DRB Application No.: 03-01119 (P&F)  
Project Name: **BERQUIST ADDITION**  
Agent: Surveys Southwest

9. **Project # 1002797**  
03DRB-01119 Minor-Prelim&Final Plat  
Approval

SURVEYS SOUTHWEST, LTD agent(s) for RAY MARES request(s) the above action(s) for all or a portion of Lot(s) T, **BERQUIST ADDITION**, zoned R-2 residential zone, located on ESTANCIA DR NW, between AVALON RD NW and CENTRAL AVE NW containing approximately 1 acre(s). (K-11) **PRELIMINARY PLAT WAS APPROVED WITH FINAL SIGN OFF DELEGATED TO PARKS FOR CASH-IN-LIEU AND TRANSPORTATION DEVELOPMENT FOR RIGHT-OF-WAY DEDICATION.**

RE: Berquist Addition, Lot T

PLAT OF
LOTS T-1 & T-2
BERQUIST ADDITION
WITHIN PROJECTED SECTION 23, T. 10 N., R. 2 E., N.M.P.M.
TOWN OF ATRISCO GRANT
CITY OF ALBUQUERQUE
BERNALILLO COUNTY, NEW MEXICO
JUNE, 2003

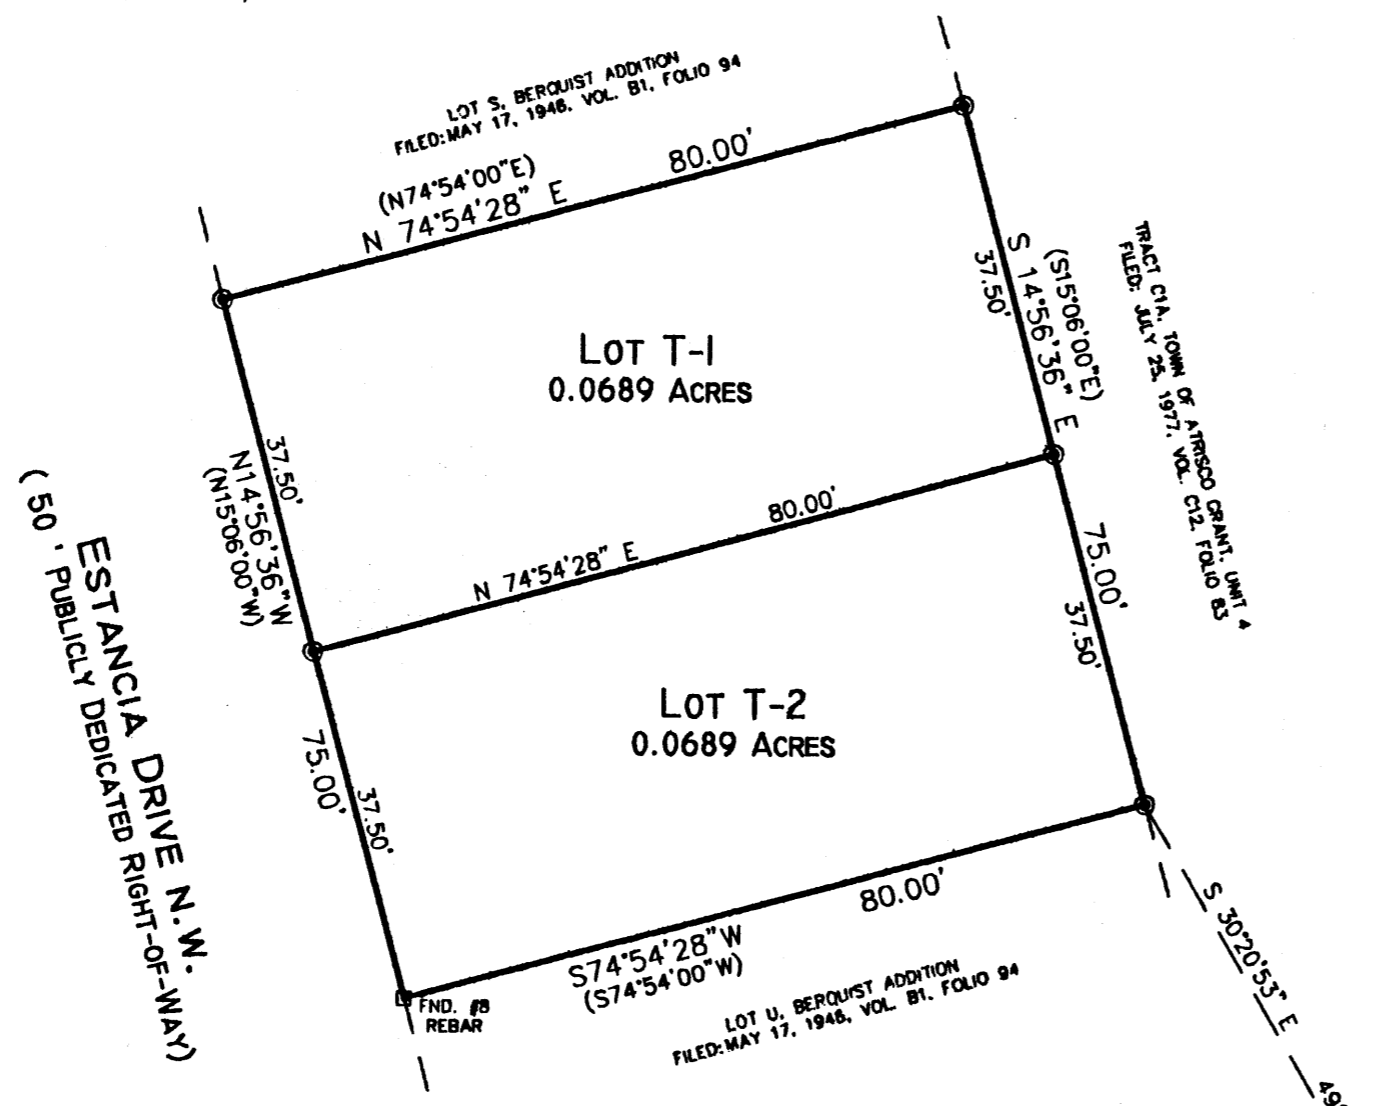
TRANSPORTATION: R/W dedication

*R/W dedication*

The size of these two lots qualify only for townhomes as they are 3,0001 square feet each. Single family must have 3,600 square feet. Apartments require 6,000 square feet minimum.

Be sure to follow the RT setback requirements when developing the lots. We are assuming the lots are currently vacant?
